STATE OF NORTH CAROLINA  
DEPARTMENT OF TRANSPORTATION

**Addendum No. 1**

RE: Contract # C204281

2 SECTIONS OF NC-98 AND 54 SECTIONS OF SECONDARY ROADS

### SUMMARY OF QUANTITIES

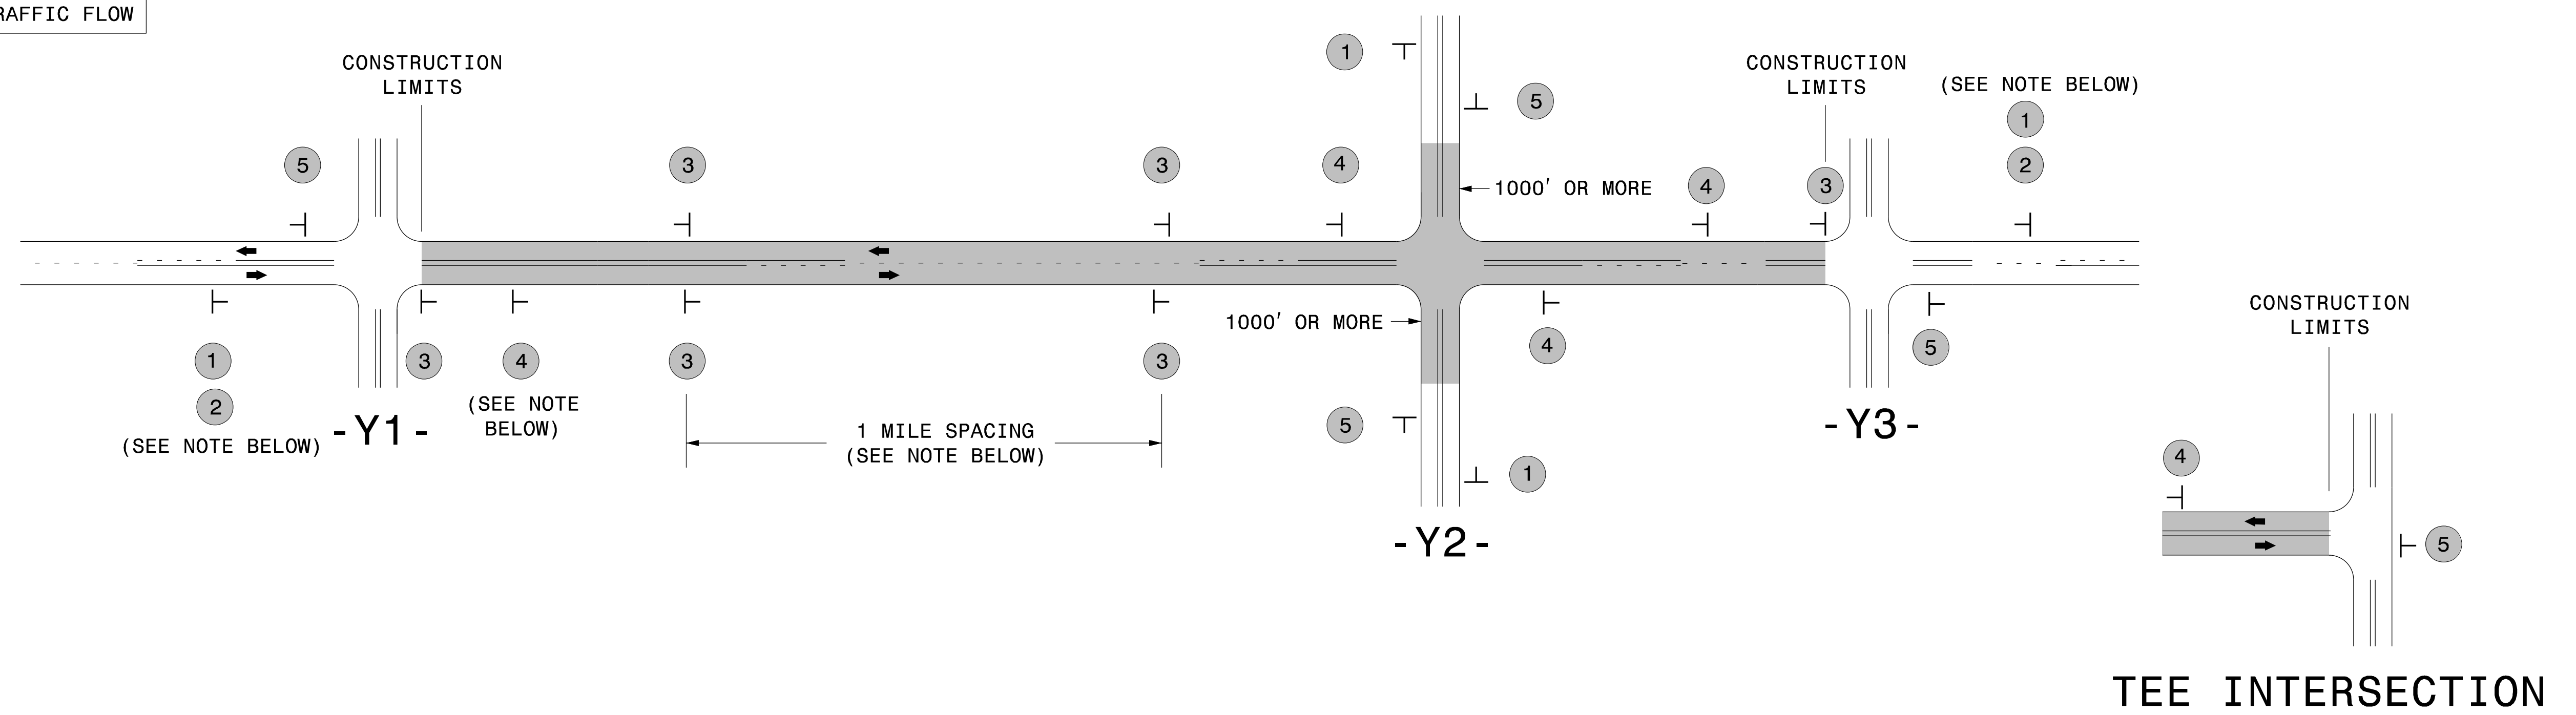
Sheet No.	Revisions
15	Revised to remove column for <i>Asphalt Concrete Intermediate Course, Type I19.0C</i> and add column for <i>Response for Erosion Control</i> .
16	Revised to remove column for <i>Asphalt Concrete Intermediate Course, Type I19.0C</i> and add column for <i>Response for Erosion Control</i> .
